DESCRIPTION OF REQUEST: DRB Final Sign off - Site Development plan for Subdivision

## OFFICIAL NOTIFICATION OF DECISION

Project# 1003275  
13EPC-40148 Site Development Plan for  
Subdivision

For all or a portion of lot I-A-1, El Rancho Atrisco Phase III, located on Unser Blvd NW between Hanover Rd NW and Ladera Dr NW containing approximately 19.98 acres.

**MAXIMUM FAR/DENSITY:**

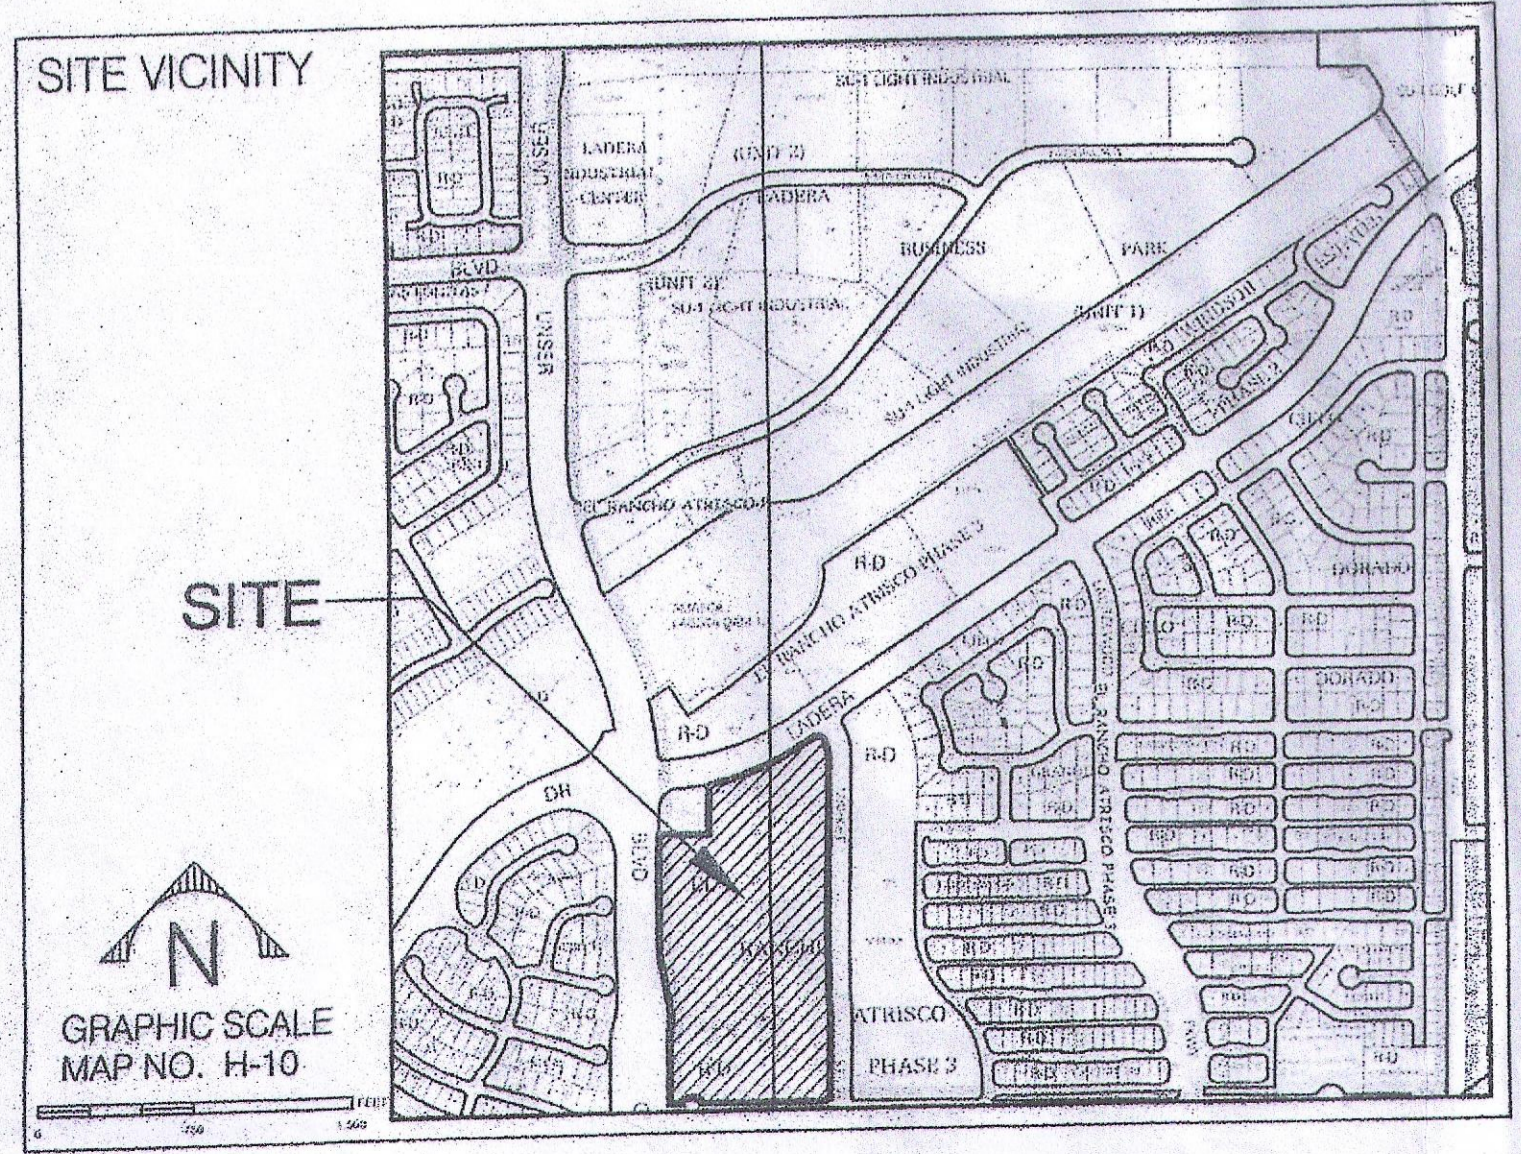
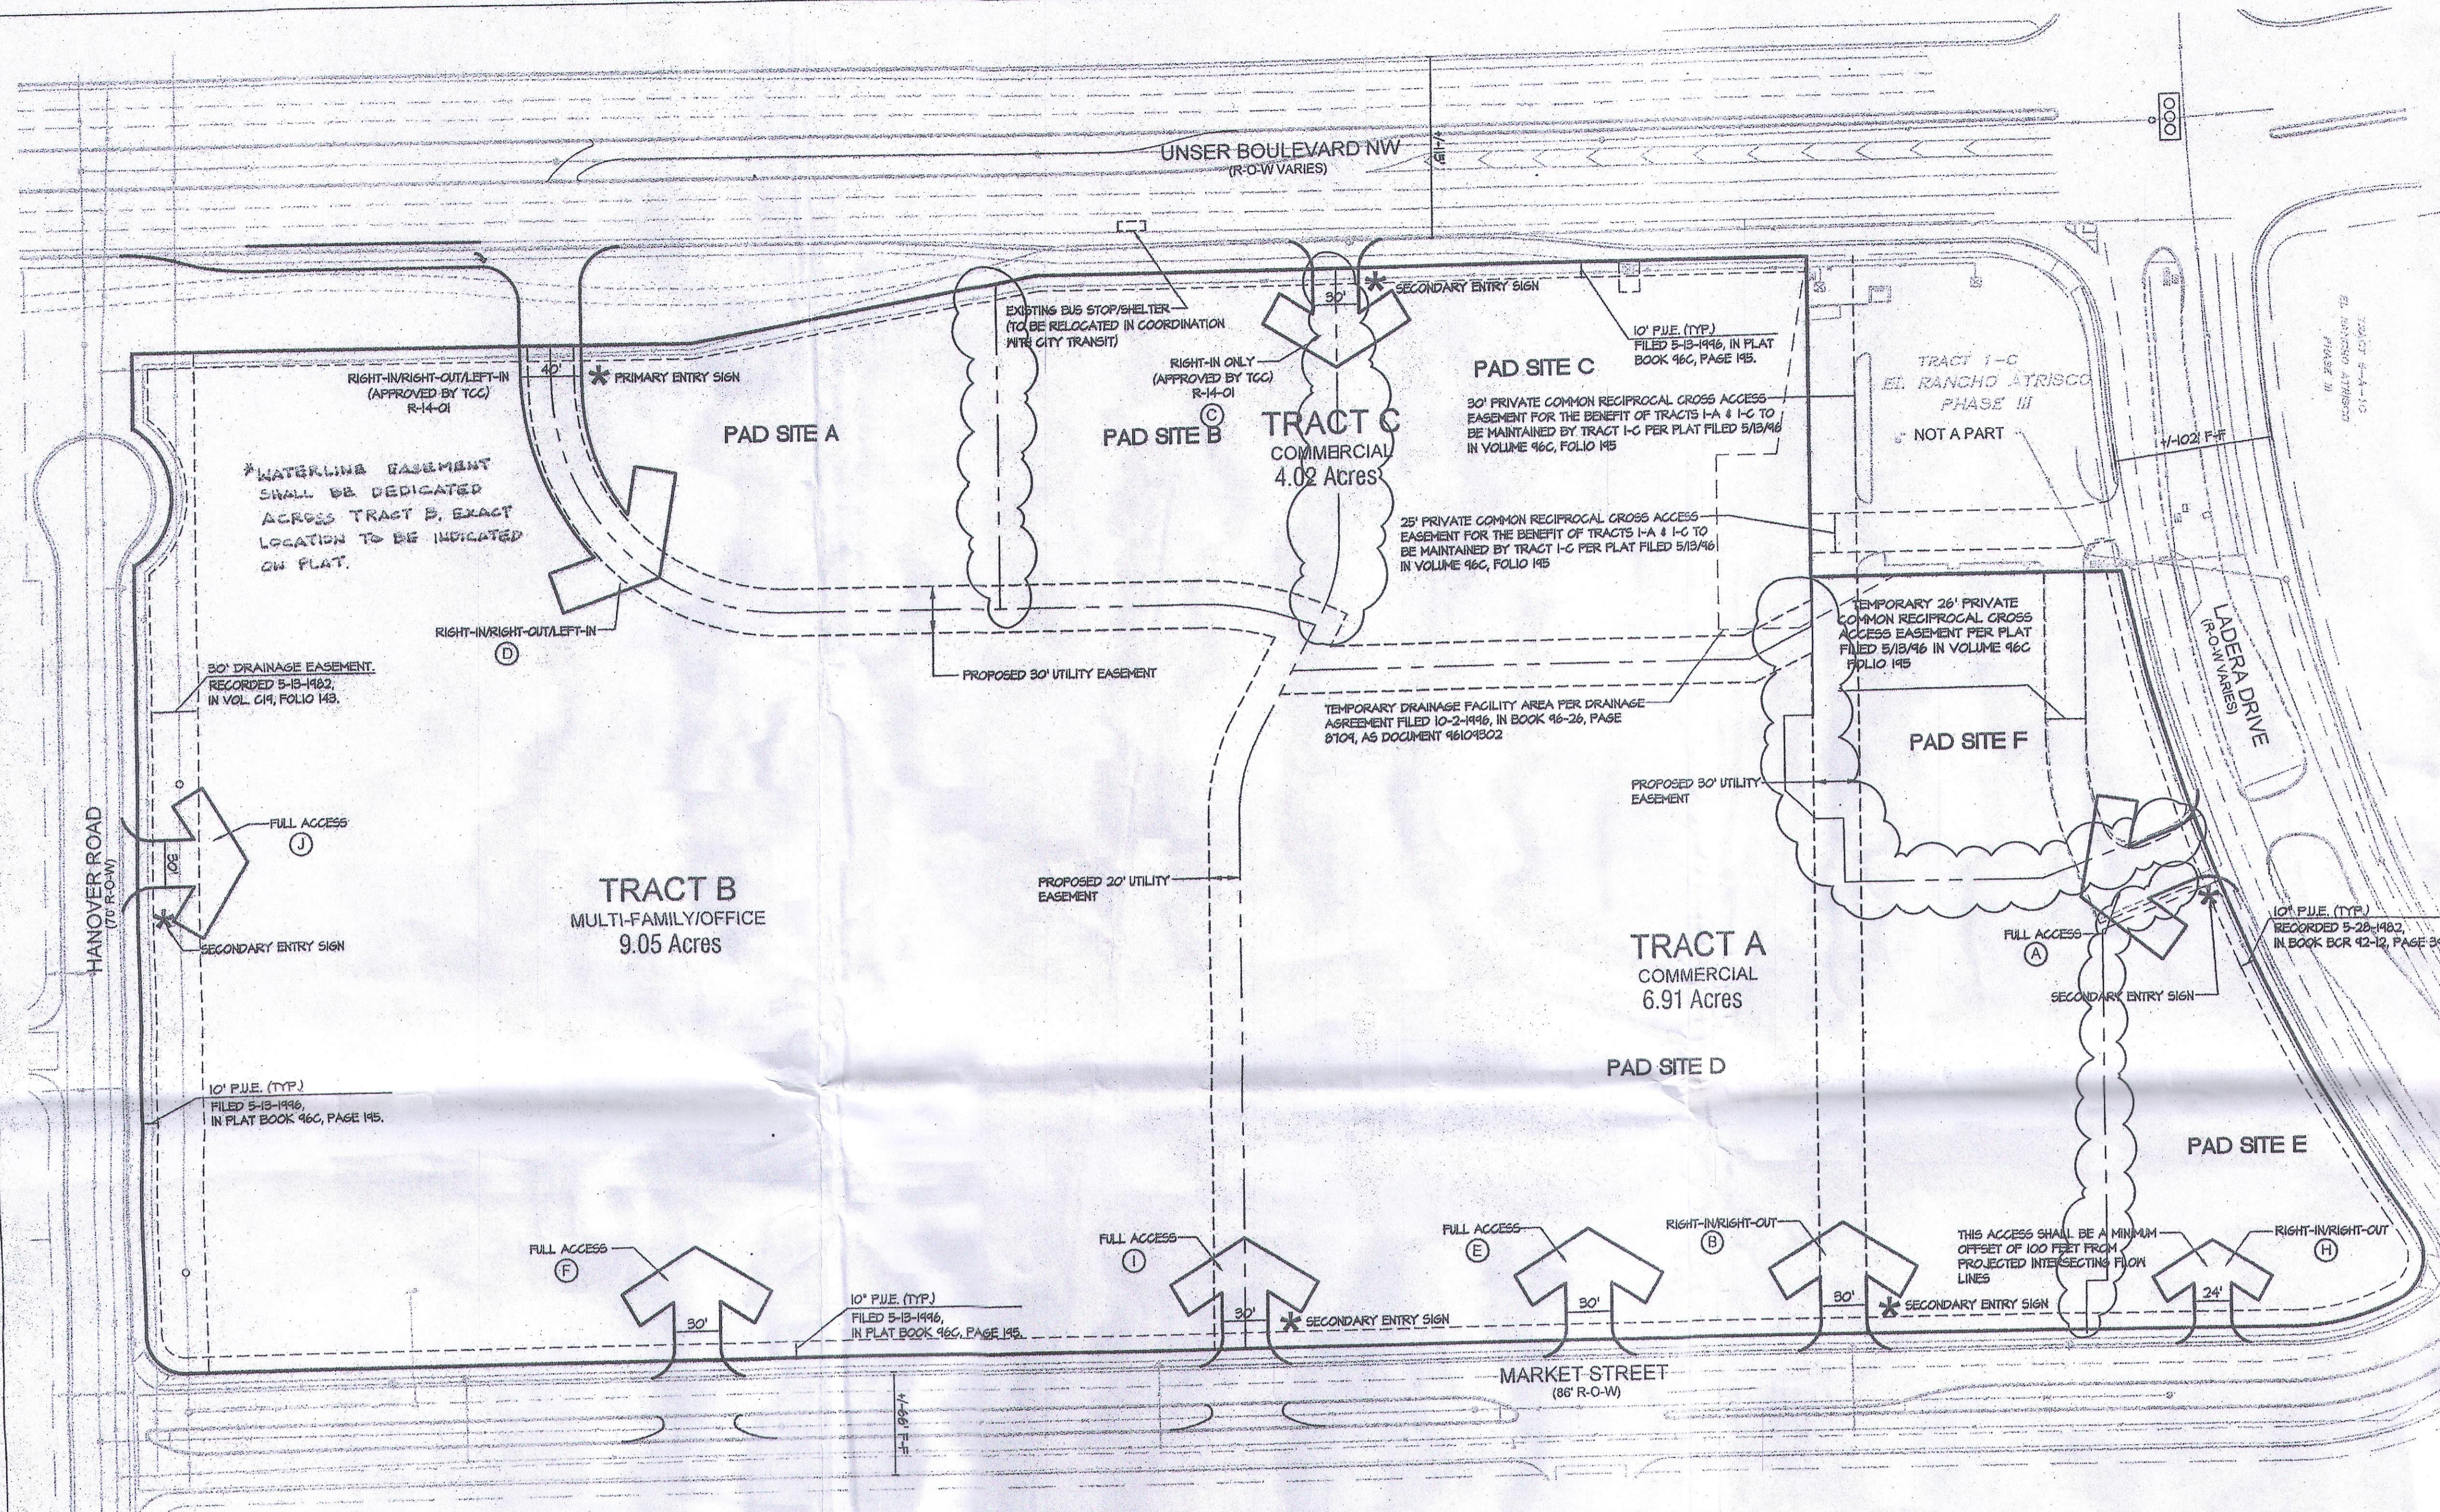
13. Revise Site Plan sheet 1, under Building Heights and Setbacks, to delete the first two sentences and replace with the following: "Maximum building heights for all buildings shall be per the SU-1 zone."
